Application: 02-50004610

COUNTY OF HARNETT LAND USE APPLICATION

IMPROVEMENT PERMIT

02-54610

1. Tammie Robinson **SITE PLAN A** Review 0  
HARNETT County, DISTRICT R  
to which this certification is affixed meets all  
requirements for recording. #BEDROOMS       
6-7-00 Tammie Robinson  
Date Review Officer Date

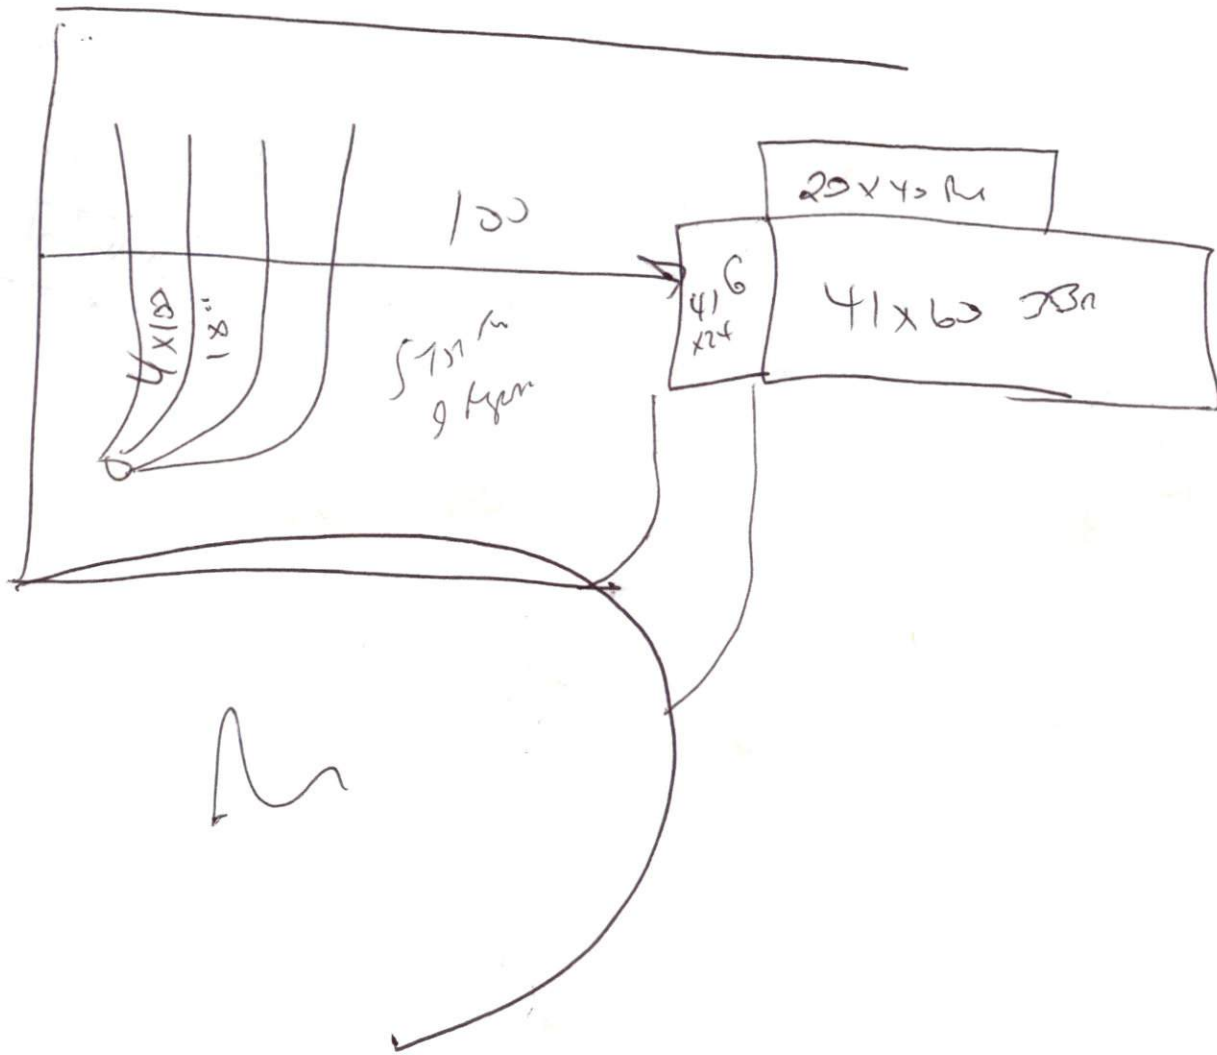
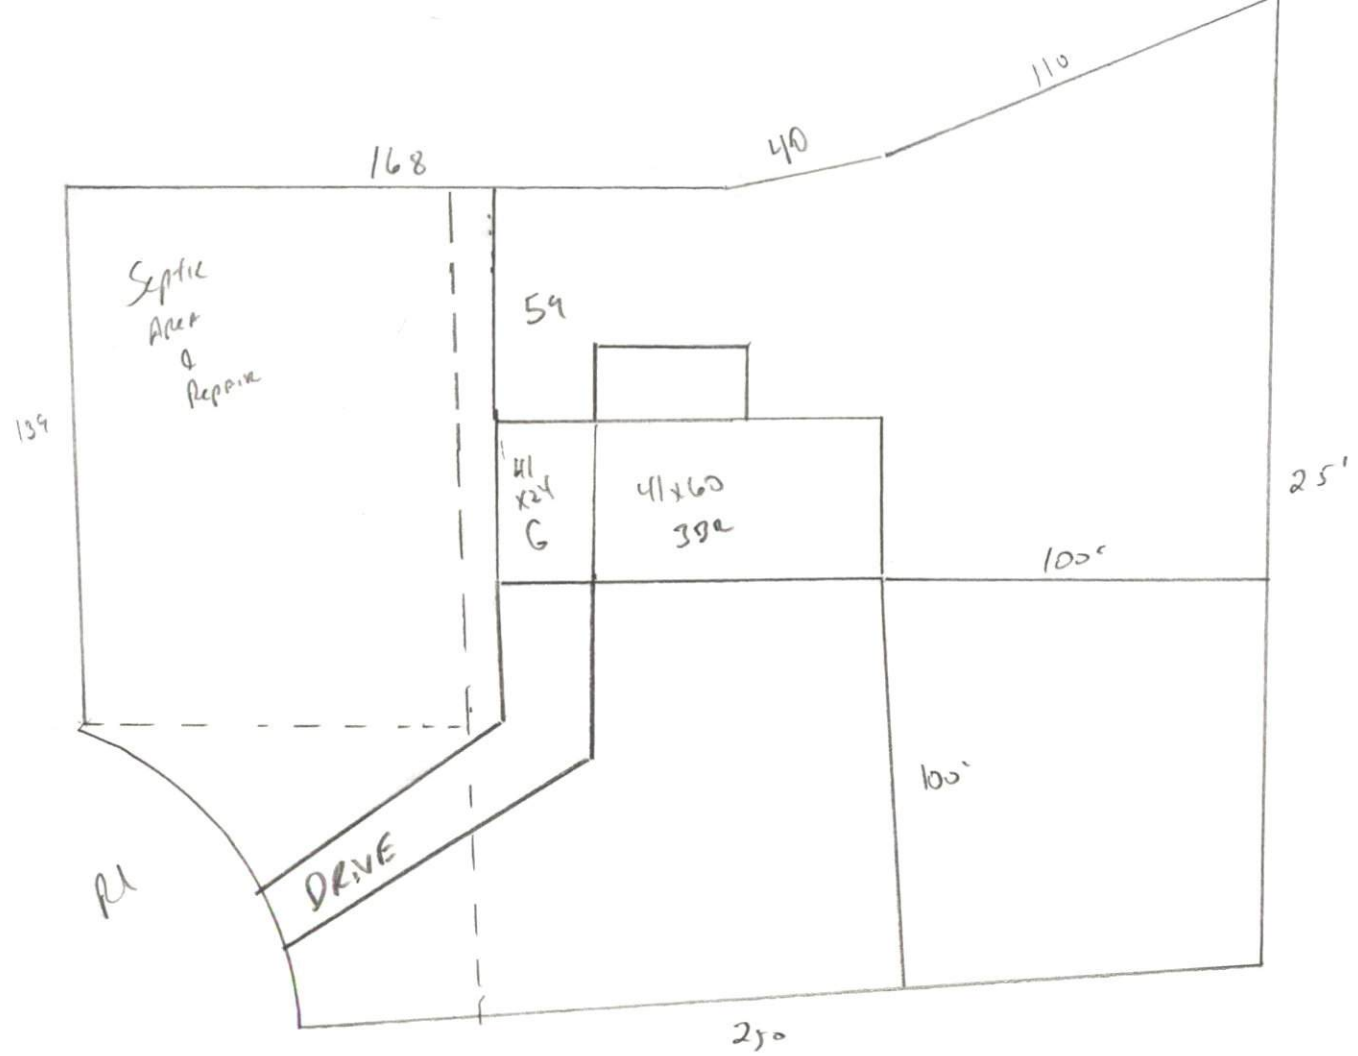
Basement with Plumbing: Garage: Please note the change in house location - Due to the size of the home, size of Garage, size of Deck & location of suitable soils - This house must be removed

Distance From Well: 50 ft. of suitable soils - This house must be removed

Plot Plan must be changed to match this permit
Maintain all set backs 18" max ditch depths Follow contours 110
Do not drive on park on septic system

Following is the minimum specifications for sewage disposal system on above captioned property. Subject to final approval. As shown on this permit

Type of system: Conventional Other Pump to Conventional

Size of tank: Septic Tank: 1000 gallons Pump Tank: 1000 gallons

Subsurface Drainage Field: No. of ditches 4 exact length of each ditch 100 ft. width of ditches 3 ft. depth of ditches 18 max in.
